From: Simon Davis
Sent: 19 November 2019 11:26
To: 'Chris Whitehouse' [REDACTED]
Cc: Paula Pemberton [REDACTED]
Subject: RE: BE/100/19/PL Springfields

Subject: BE/100/19/PL Springfields

REV.	DESCRIPTION:	BY:	DATE:	PROJECT:	SCALE @A1:	DATE:
-	-	-	-	Land to the north of Springfields	1:50/100	09/08/19
				CLIENT:	PROJECT NUMBER:	DRAWING NUMBER:
				Mr C Thorne	0520-03	0520-03/03
				TITLE:	DRAWN BY:	CHECKED BY:
				Proposed Floorplans and Elevations - Plot 1	RL	CW
					REVISION:	-

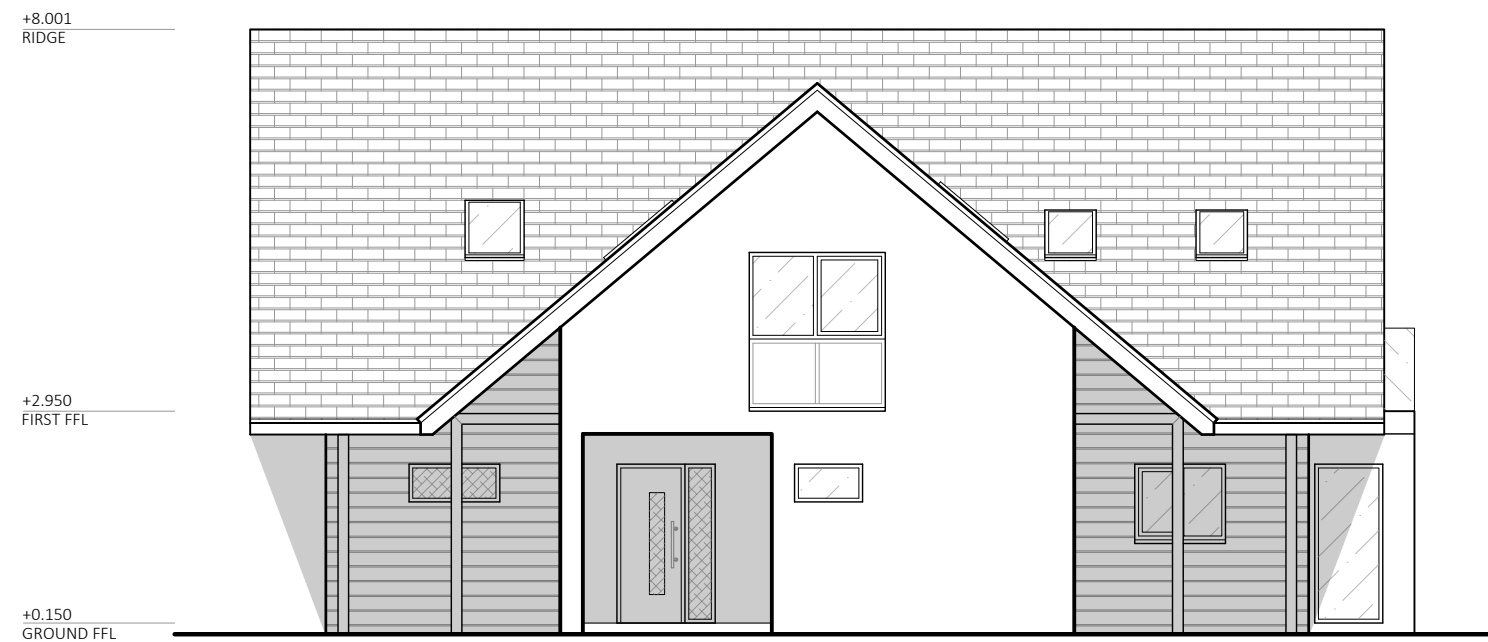
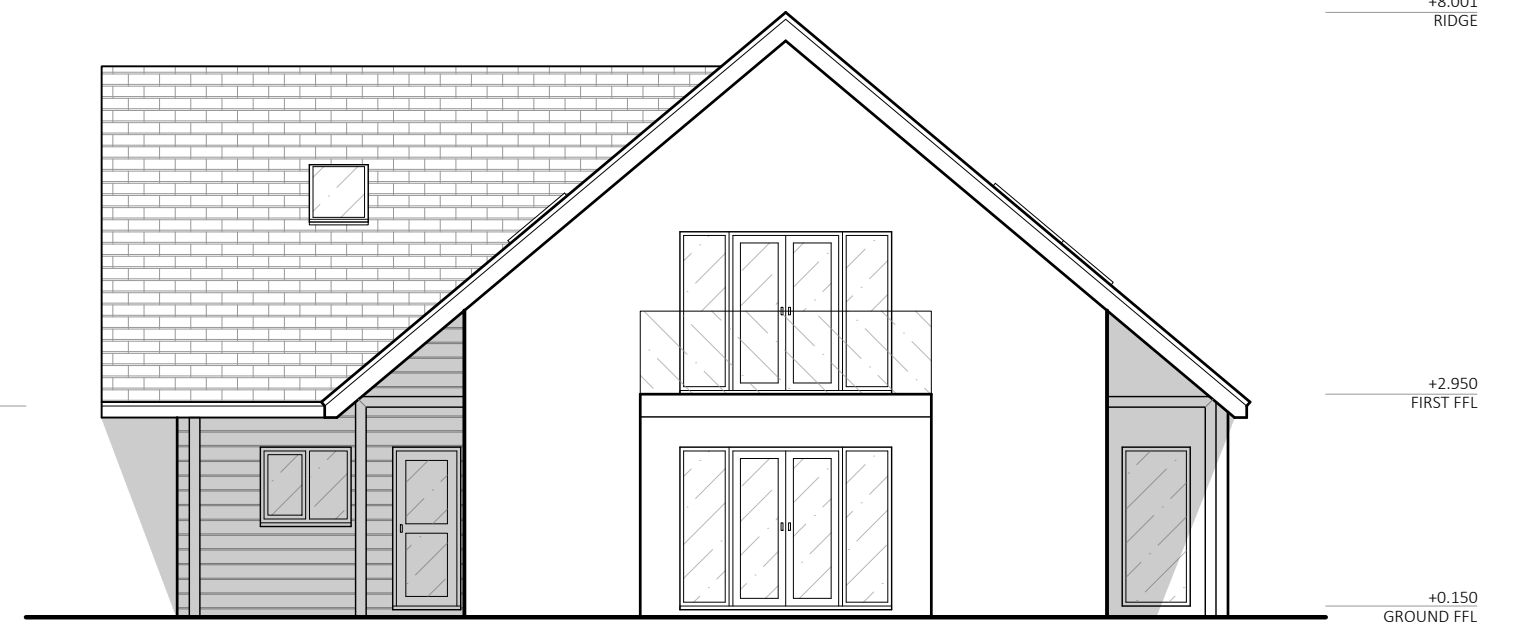
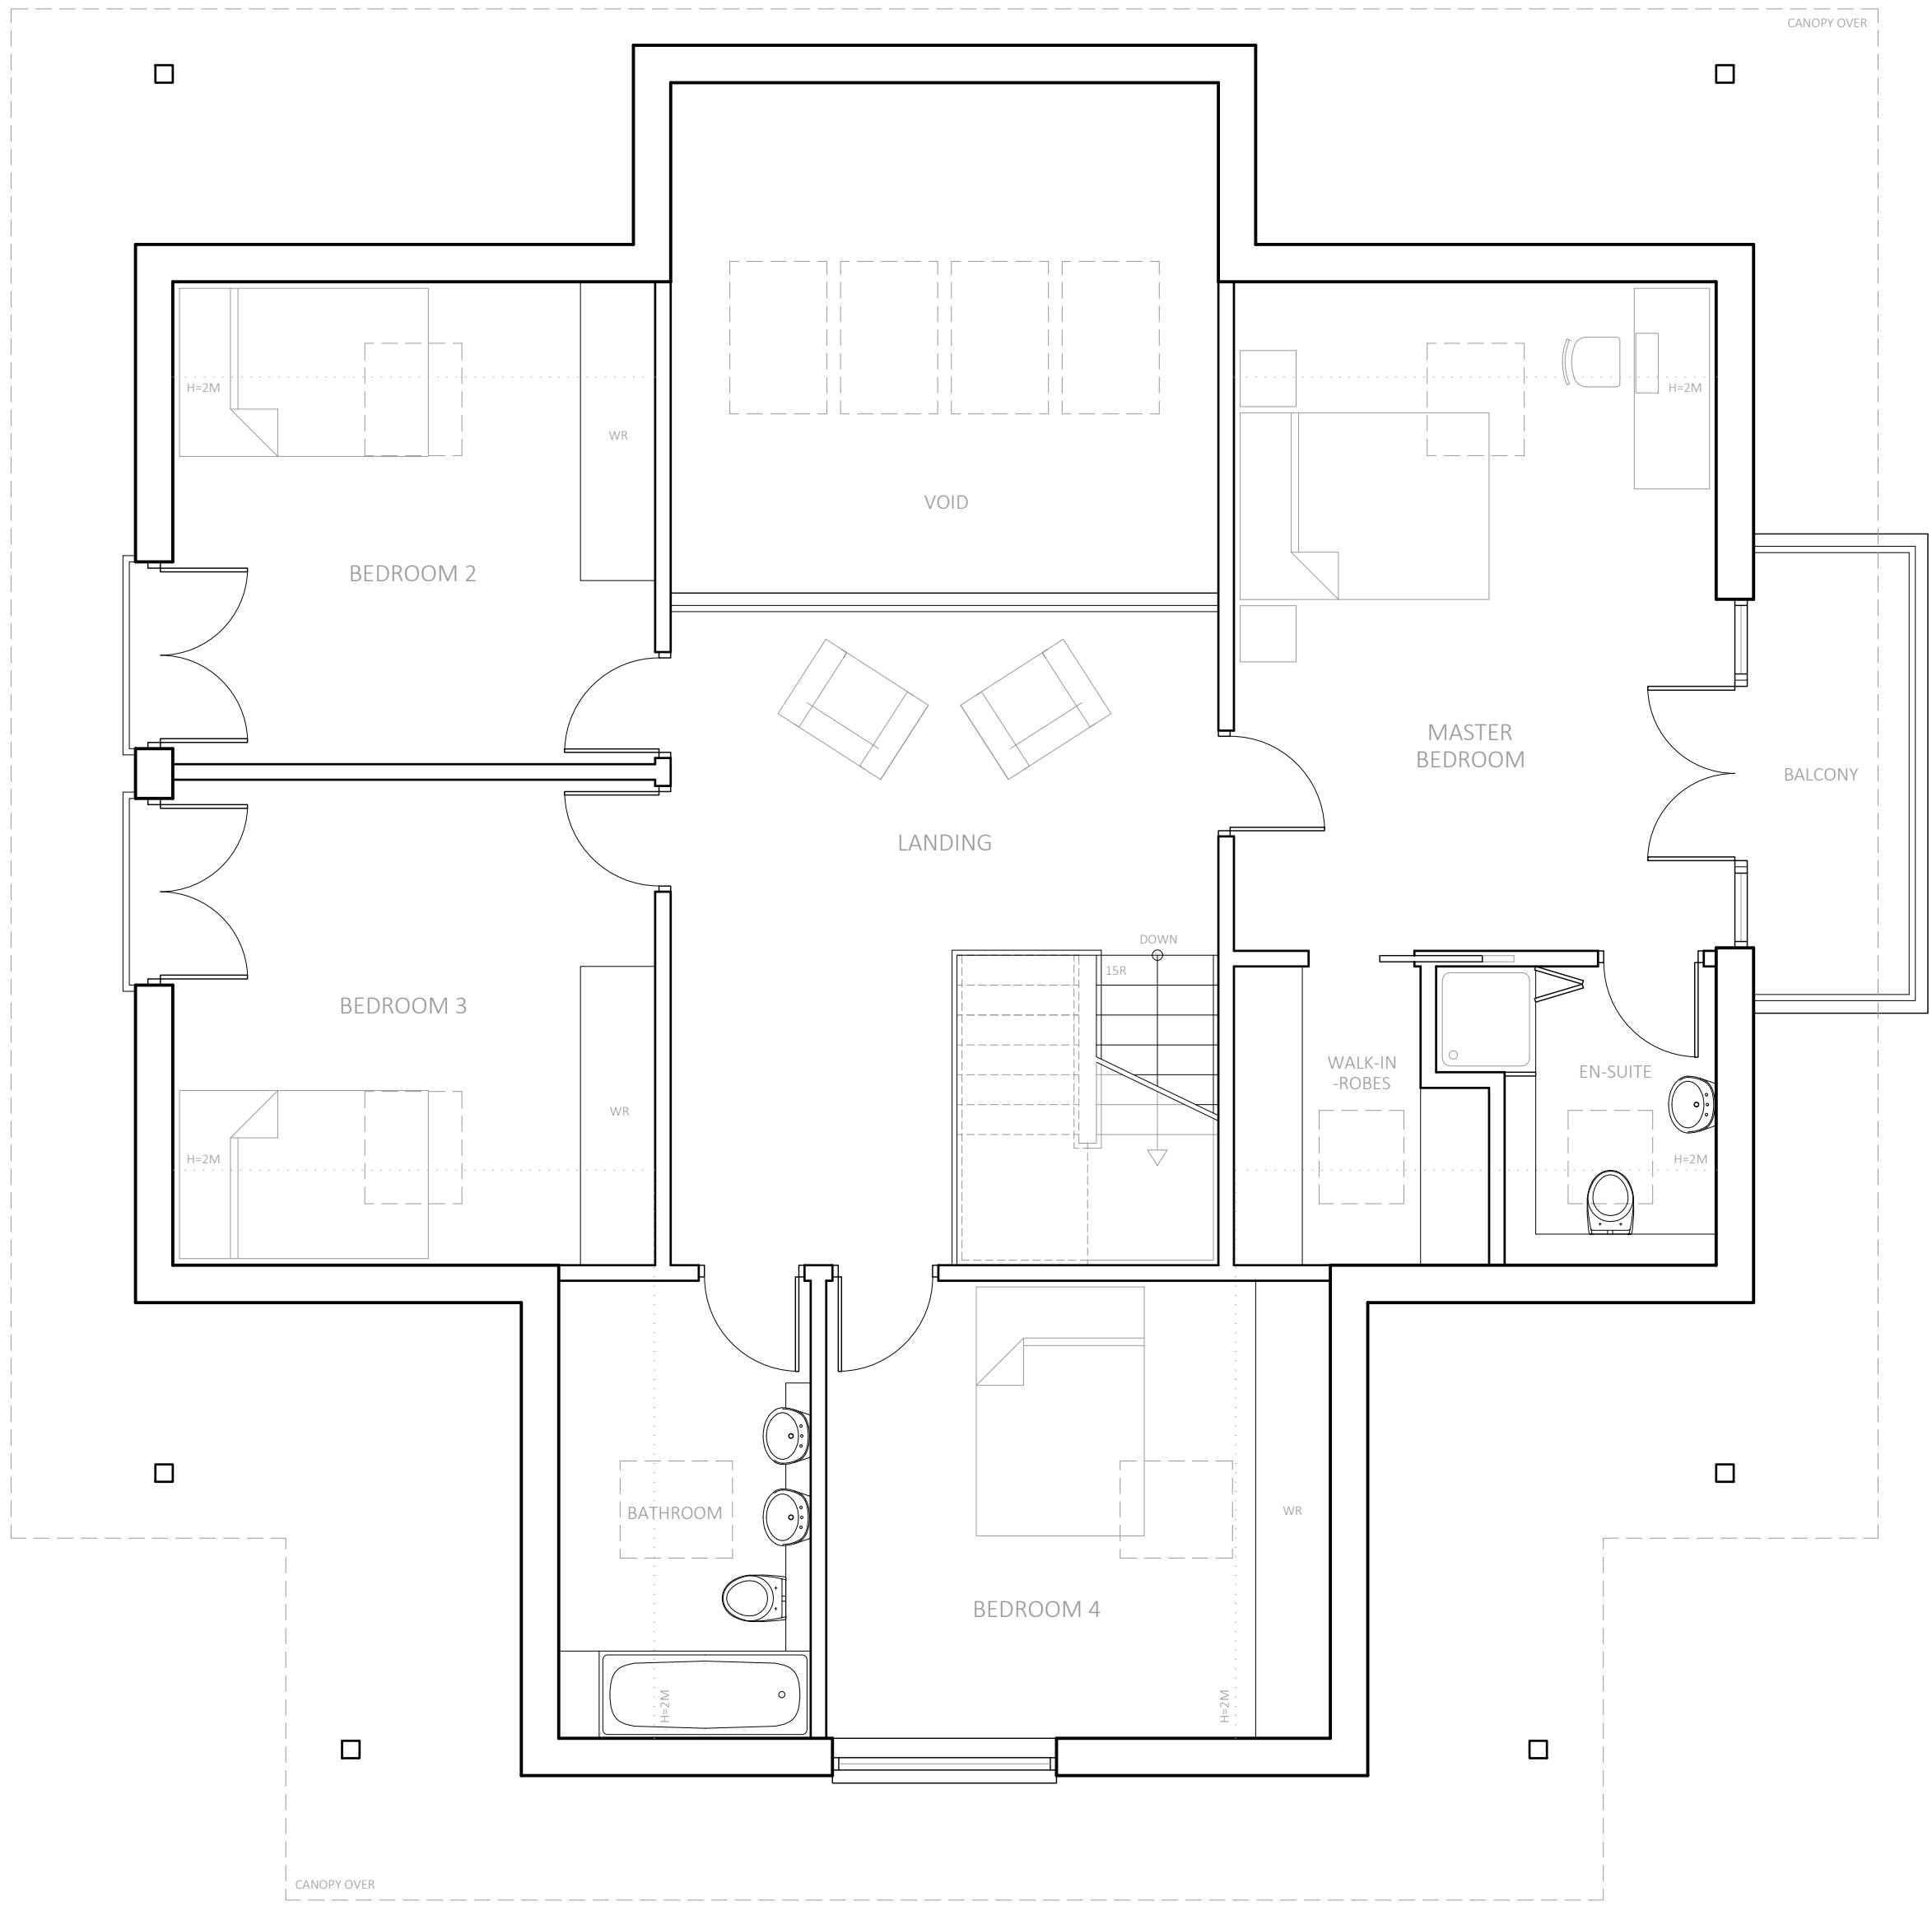
I also have some concerns with the proposed house designs in that the two pairs of Juliet balcony windows will allow overlooking of each other and also that the balcony on the south elevation to plot 1 will overlook the approved new dwelling. I note that there are limited windows on the rear east elevation (at FF) and wonder if more could be made of this elevation to avoid the overlooking from the flank FF windows.
